WEST SUSSEX COUNTY COUNCIL CONSULTATION

TO:	Arun District Council FAO: Anita Gardner
FROM:	Highways, WSCC
DATE:	22 nd February 2019
LOCATION:	Lanes End, West Walberton Lane, Walberton, West Sussex, BN18 0QS
SUBJECT:	WA/7/19/RES Approval of reserved matters following outline consent WA/26/18/OUT for layout & scale for 6 No. dwellings & 6 No. detached garages
RECOMMENDATION:	ADVICE-MORE INFORMATION
S106 CONTRIBUTION TOTAL:	£N/A

PJ DEVELOPMENTS LTD 2 Square Chambers 23 High Street Emsworth PO10 7AQ Tel: 0843 289 3430 Email: enquiries@pjdevelopmentsltd.com	
PROJECT: FORMER LANES END	
SITE PLAN OUTLINE PLANNING APPLICATION	
DATE: JANUARY 2019	DWG. NO 19-001 PL02
SCALE @ A1: 1:200	
REV: C

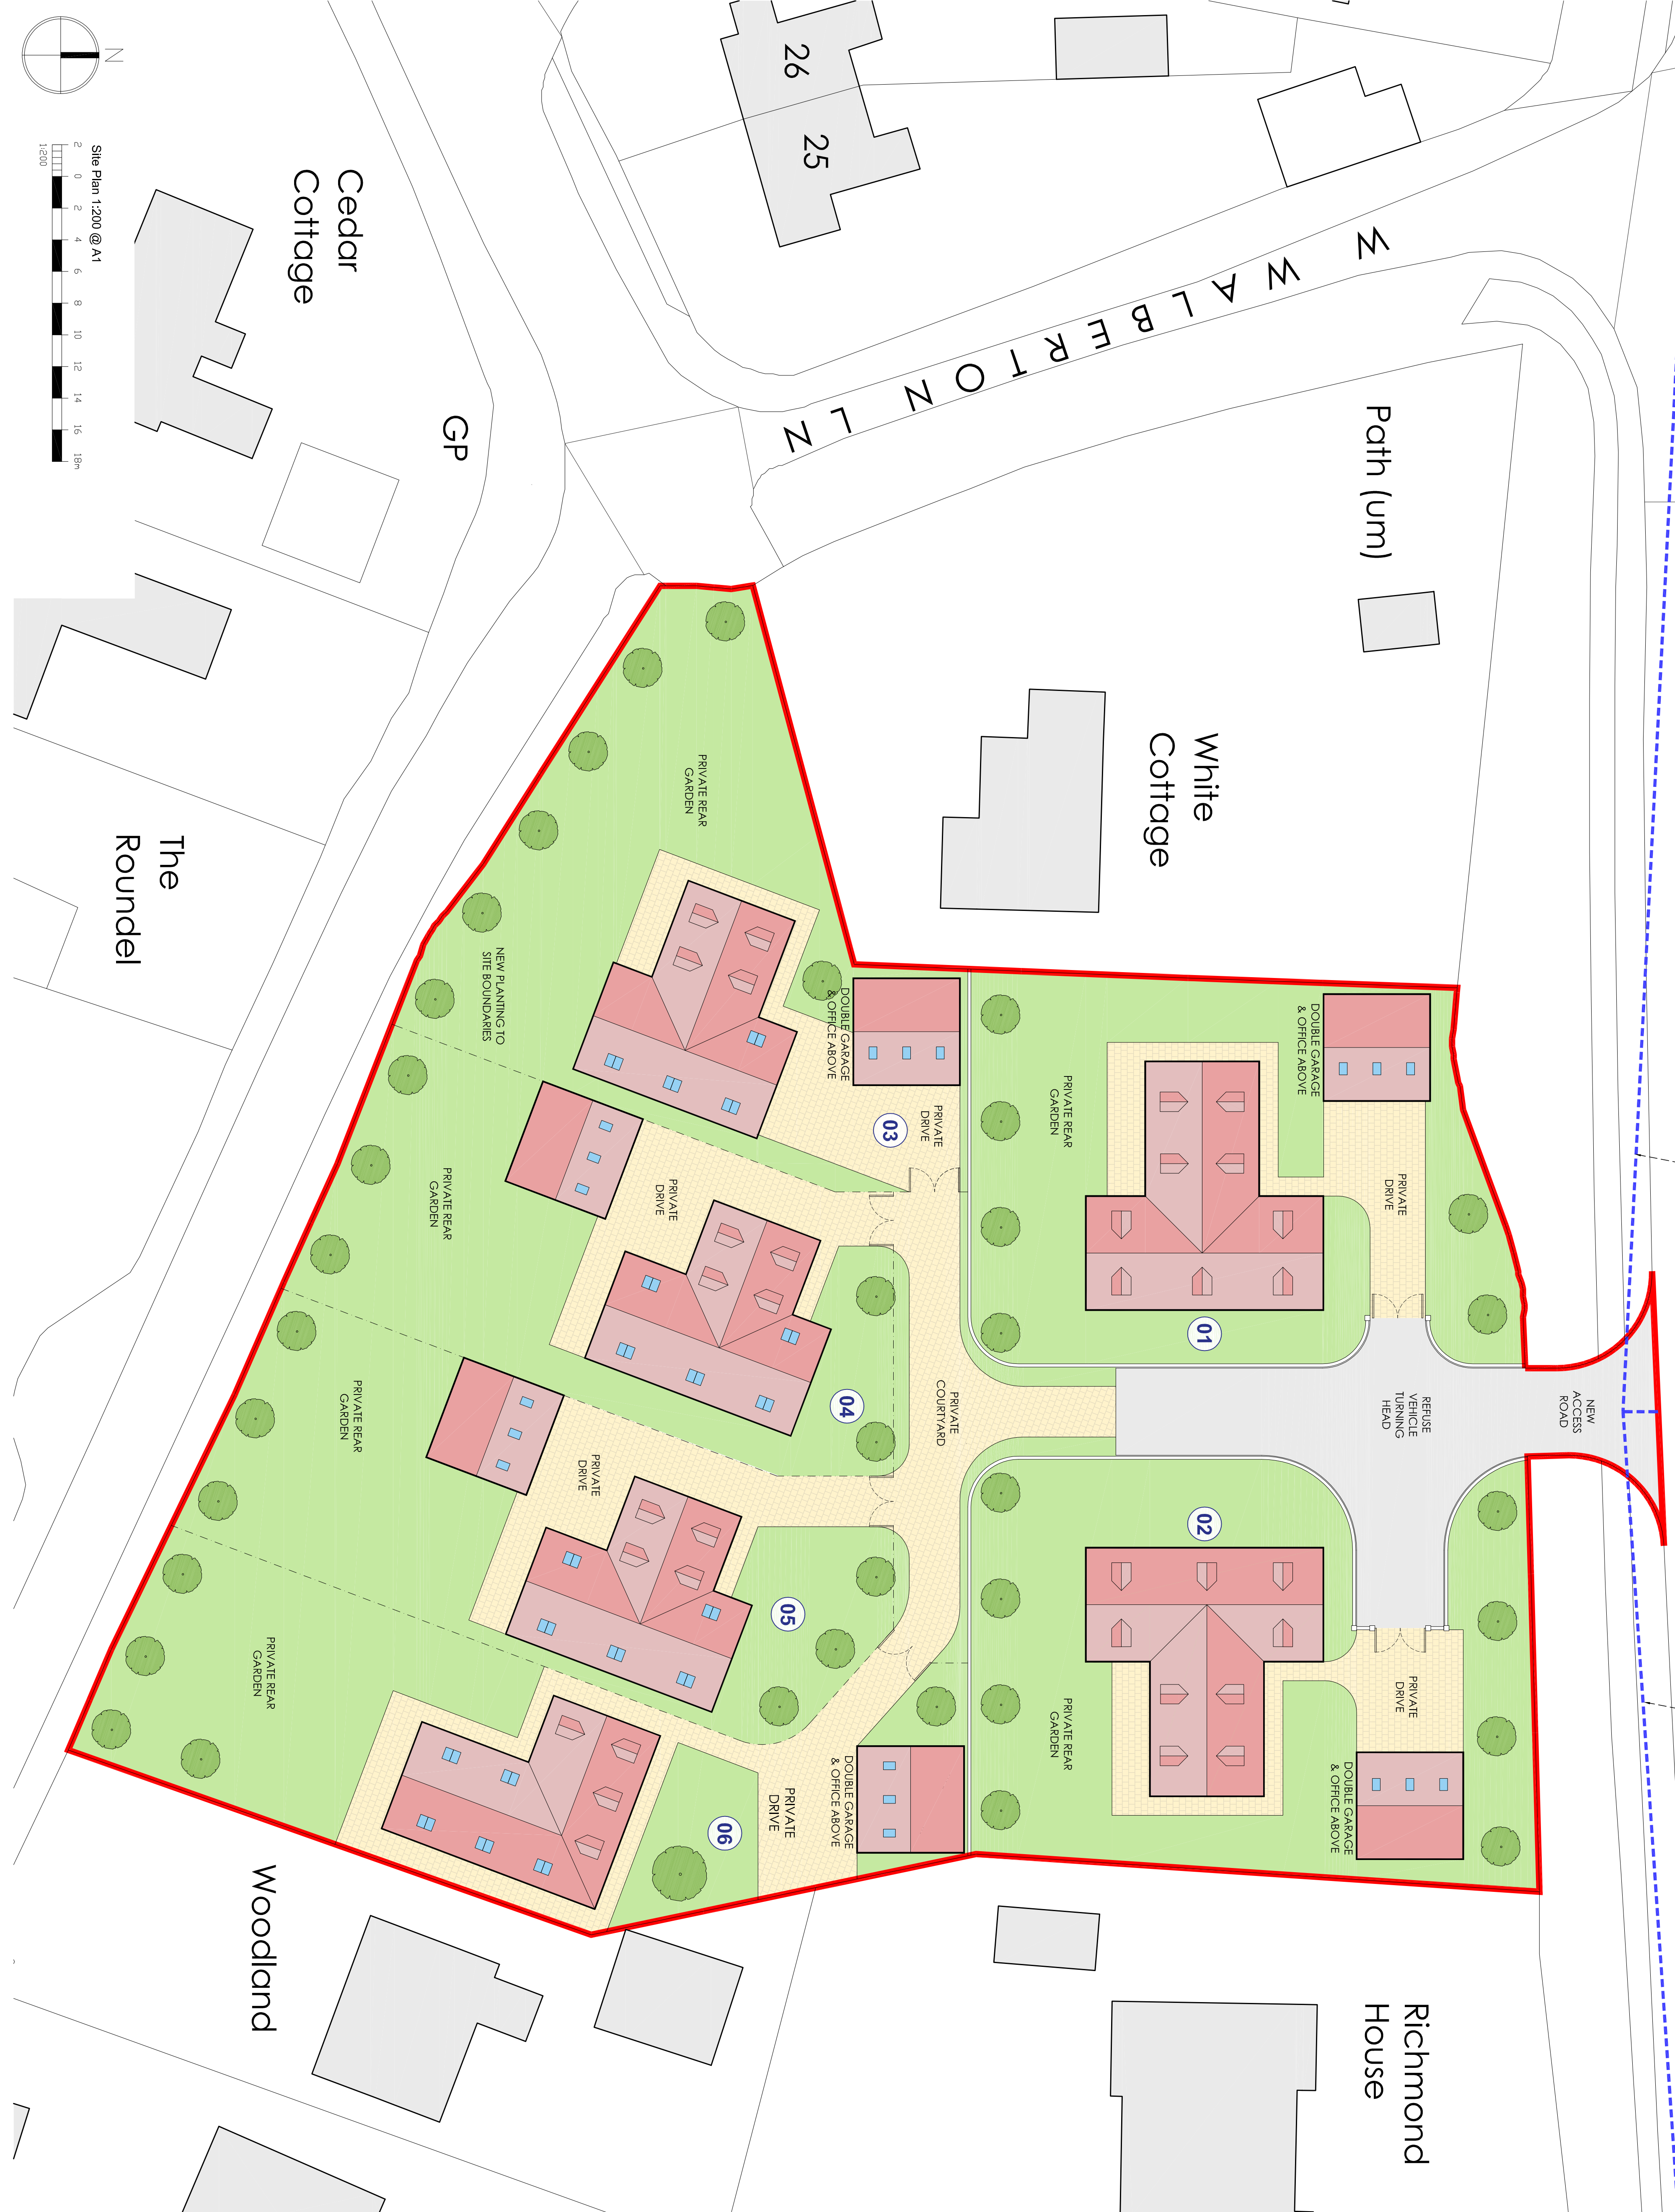
The access is wide enough for two cars to pass but the applicant has not demonstrated that a refuse collection vehicle or fire appliance can enter and turn on site in order to exit in a forward gear. The applicant should clarify whether refuse collection will be from the roadside or within the site and demonstrate via swept path tracking that a fire appliance can enter and turn on site. Fire appliance is required to reach within 45m of the furthest point of each building as per MfS paragraph 6.7.2, from an inspection of the plans this does not appear possible for all plots. WSCC Water Access Manager has been consulted and comments will be forwarded in due course.

Floor plans have not been provided and thus the LHA is unable to assess the parking demand of the development. The applicant should provide floor plans so that the LHA can assess the parking demand based on the habitable rooms and location of the site. Double garages are provided, these should measure 6m by 6m internally – floor plans should be provided. It is evident that there is sufficient space within the site for cars to turn to exit on to the public highway in a forward gear.

In summary the principle of the scheme is acceptable however the applicant is required to provide further demonstration of the proposals in the form of floor plans (houses and garages), clarification of refuse collection and demonstration via swept path tracking that refuse and fire appliance can turn within the site, ideally reaching within 45m of furthest point of each building.
